**From:** Bloomer, David <David.Bloomer@lancashire.gov.uk>  
**Sent:** 28 April 2017 09:39  
**To:** Stephen Kilmartin  
**Cc:** LHS Customer Service; planning  
**Subject:** app3/2017/0346 Land off Mill Lane Gisburn

The proposals are similar to previous applications for this site with alterations to the orientation of the proposed buildings. As the concept of the proposal and point of access have previously been agreed I would raise no objection to the proposal on highway grounds but would request that the following conditions, as previously required under planning permissions 3/2015/0759 and 0167 be attached to any permission that may be granted.

**PROPOSED PLAN AND ELEVATIONS (GARAGE)**

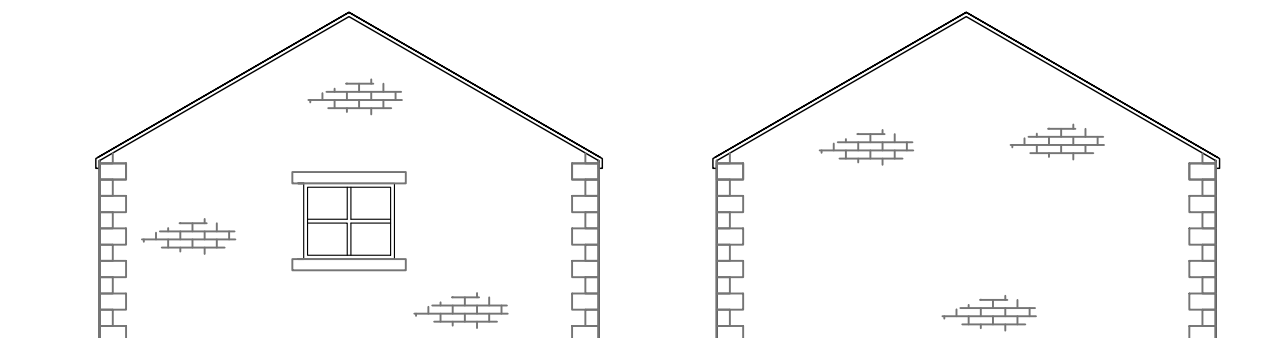
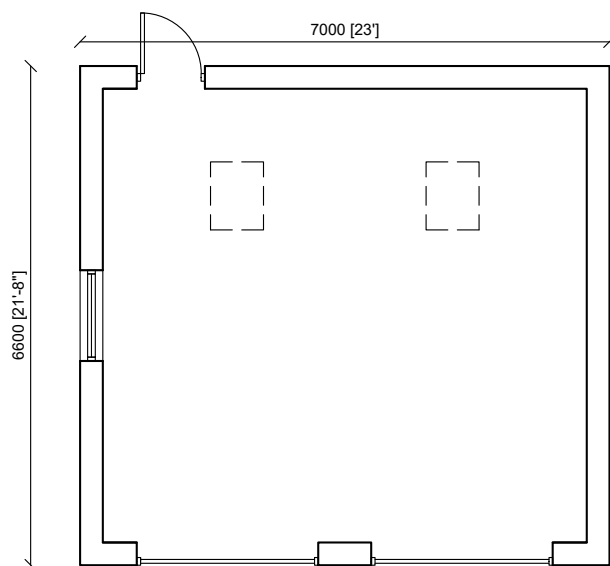
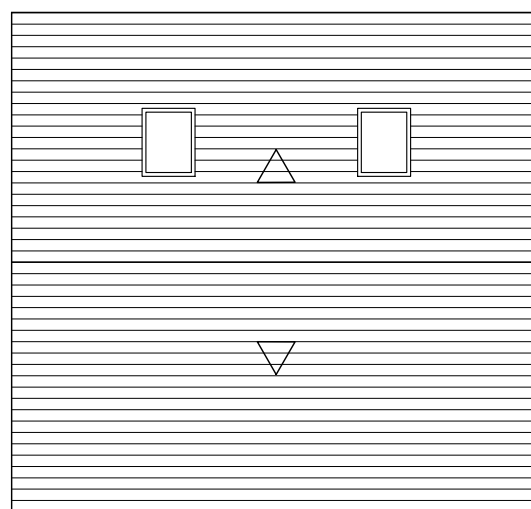
2 The garages hereby approved shall be kept available for the parking of cars and no works, whether or not permitted by the provisions of the Town and Country (General Permitted Development) Order 1995 or any order amending or revoking and re-enacting that order, shall be undertaken to alter or convert the space into living or other accommodation unless express planning permission is first obtained by the local planning authority.
